Subject: Dewsbury Riverside: Allotment at Ravensthorpe Road

Reference: PLANNING APPLICATION 2021/62/90552/E

client	Kirklees Council
project	Allotment Relocation
drawing	Proposed Allotment General Arrangement Proposed Fencing Set Out - Elevations, Sections & Details
project number	2020_00326_001
scale	As Shown @A1
drawing number	197911-AHR-AL-S0-DR-A-PL-007 P03
rev	P03
issue status	Planning

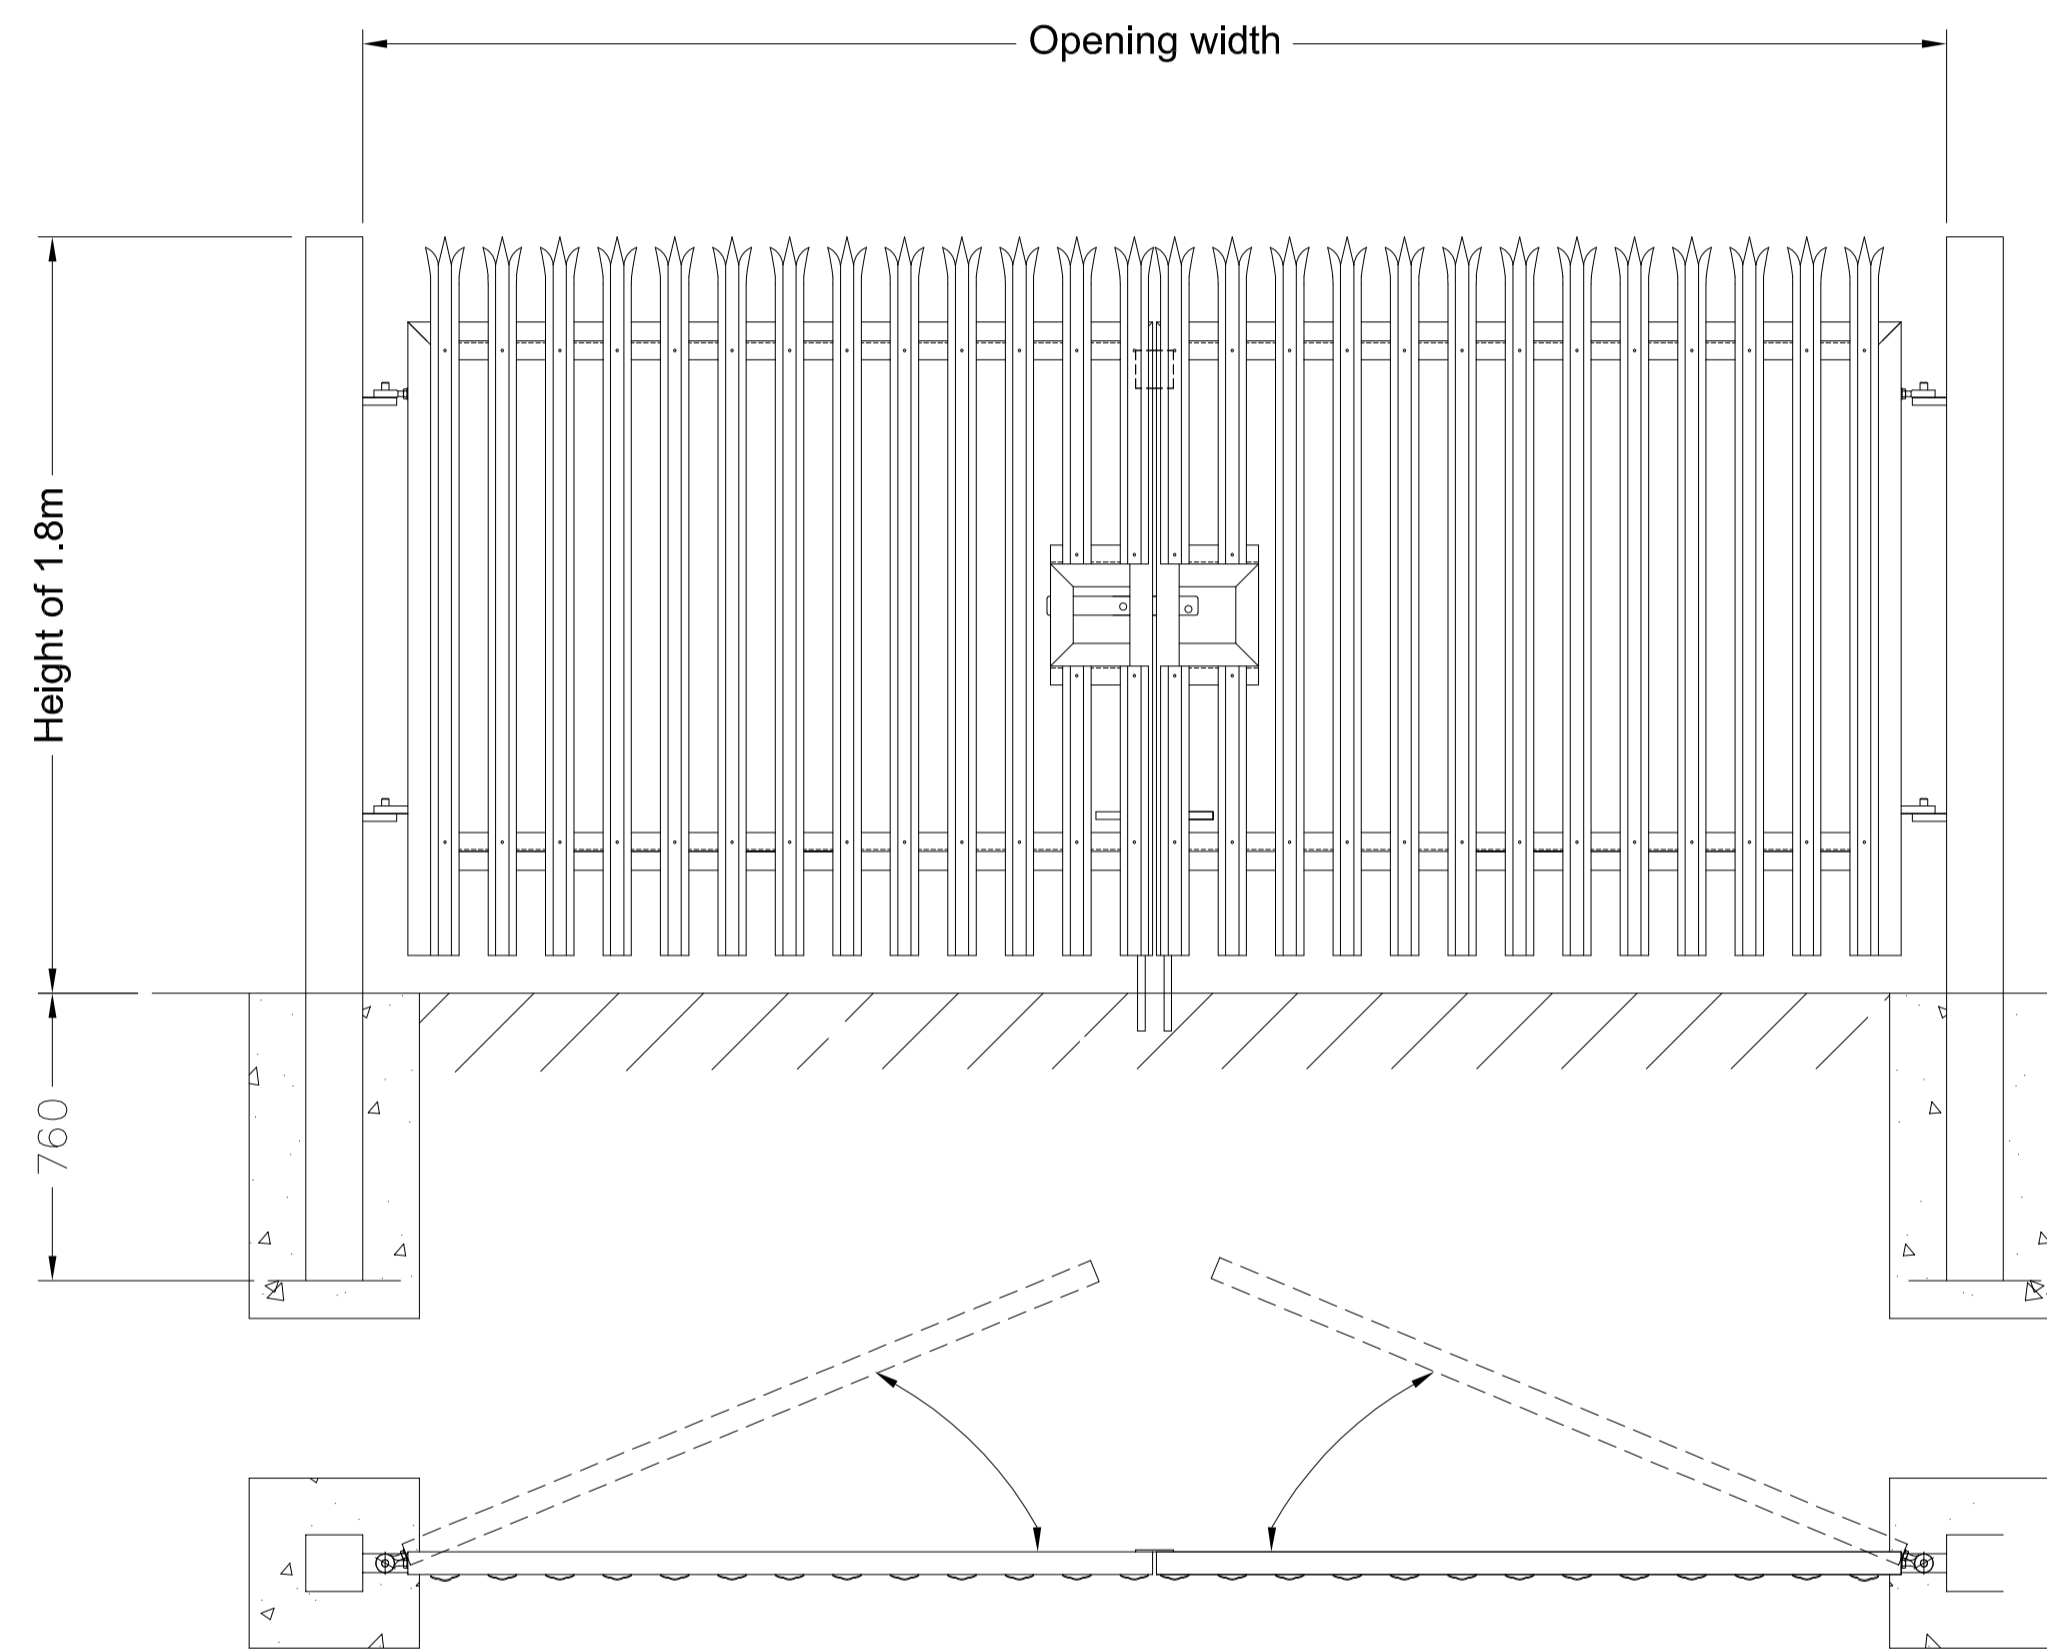
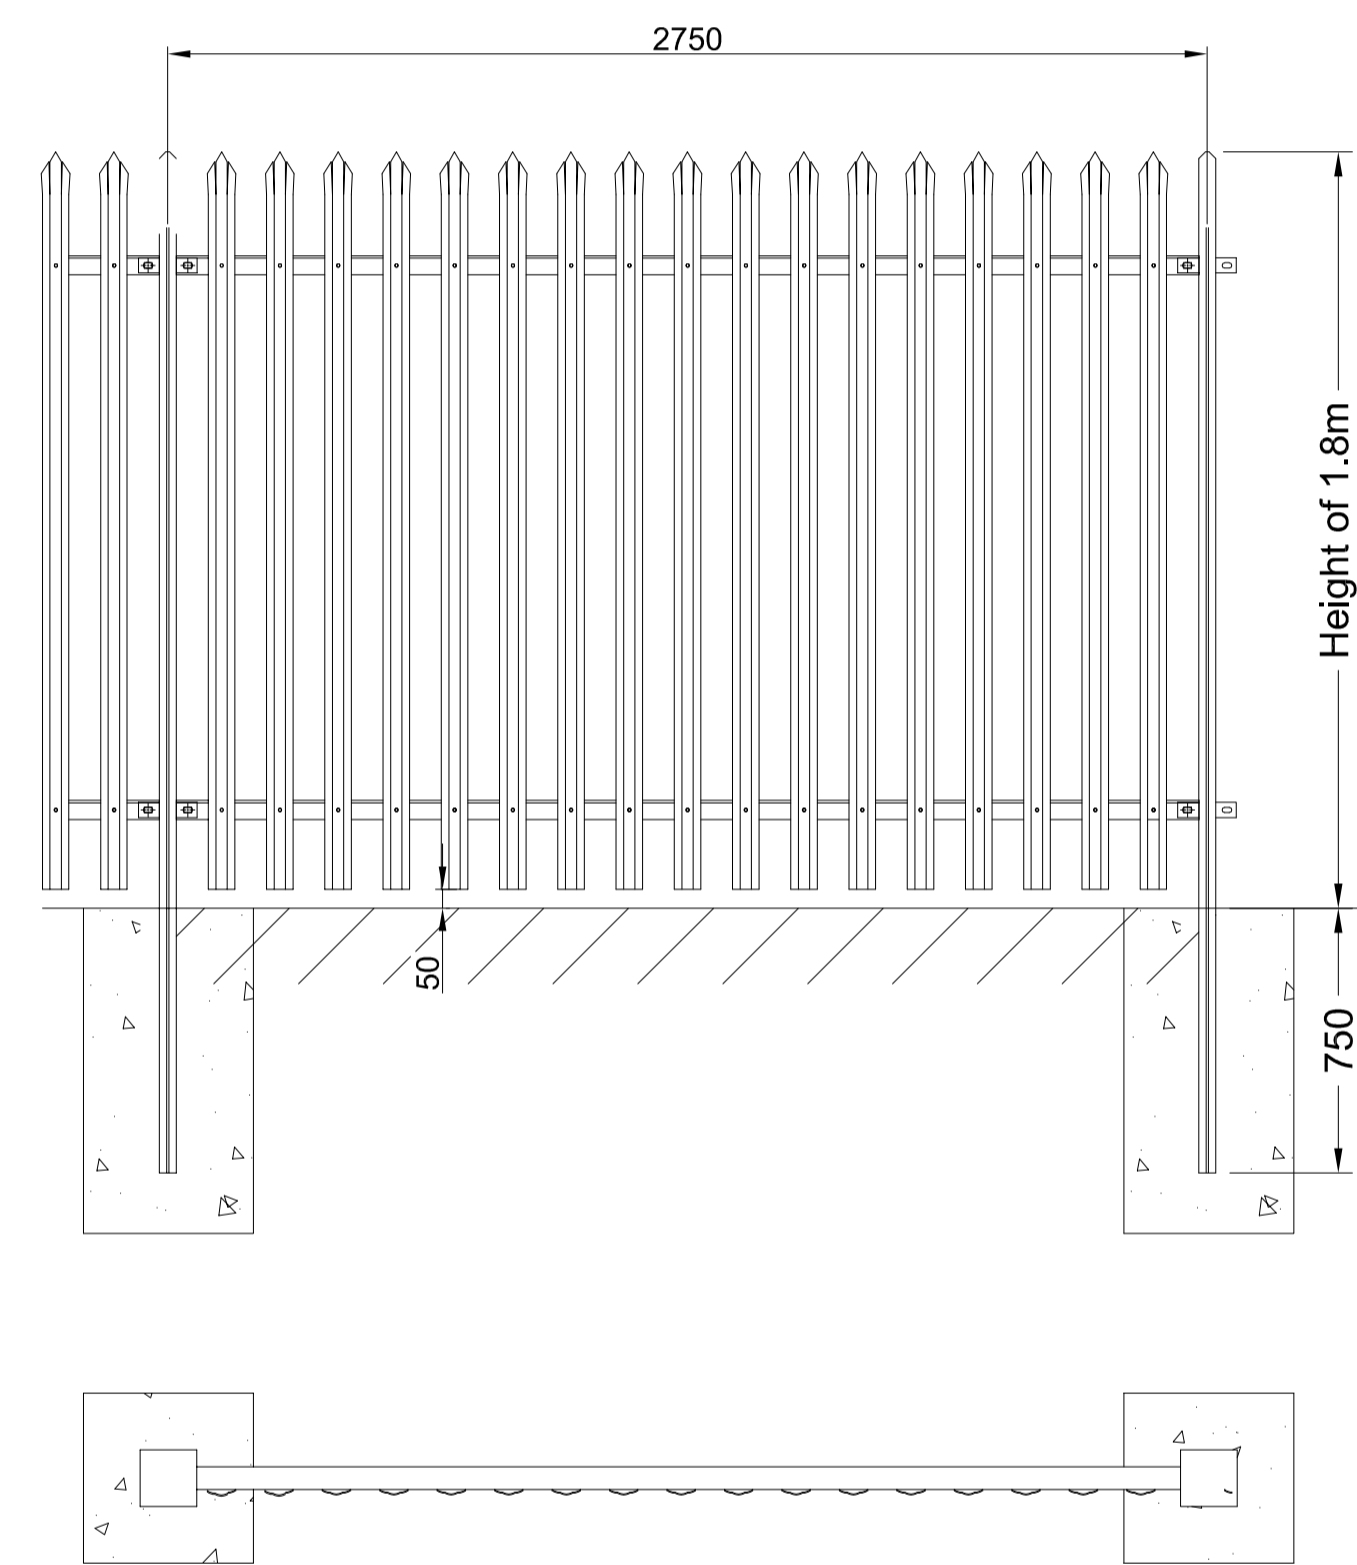
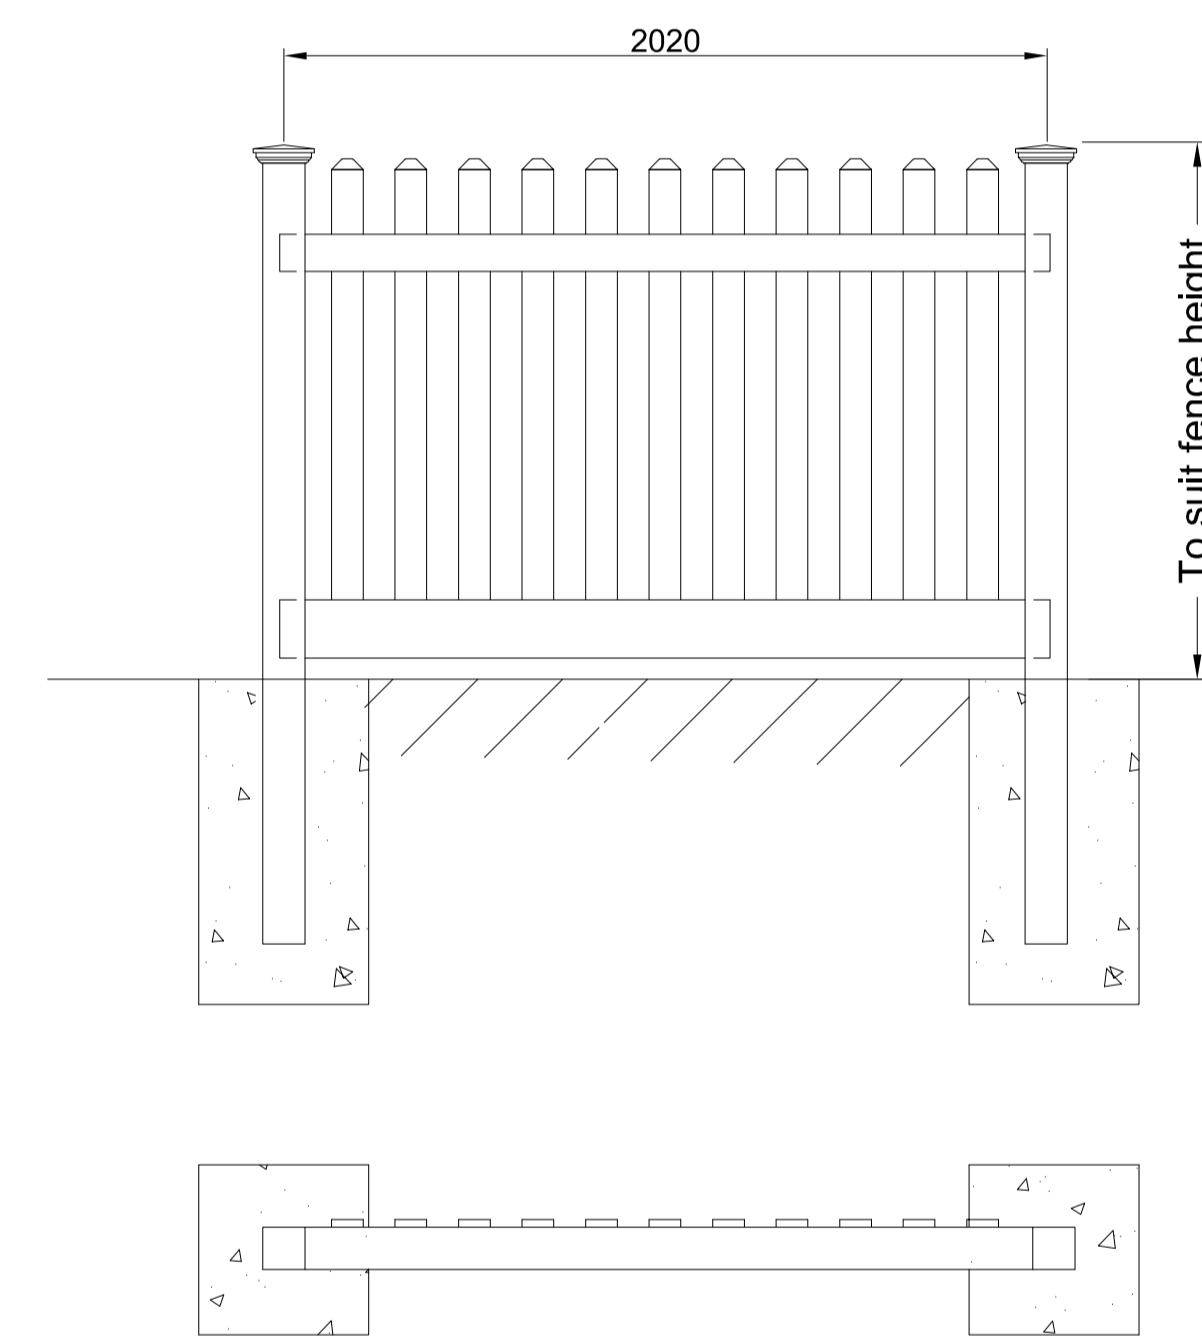
5. Is provision being made for each individual new allotment to be securely fenced to ensure separation from neighbouring allotment holders and to ensure the ability to work each separate allotment with a degree of autonomy/privacy?
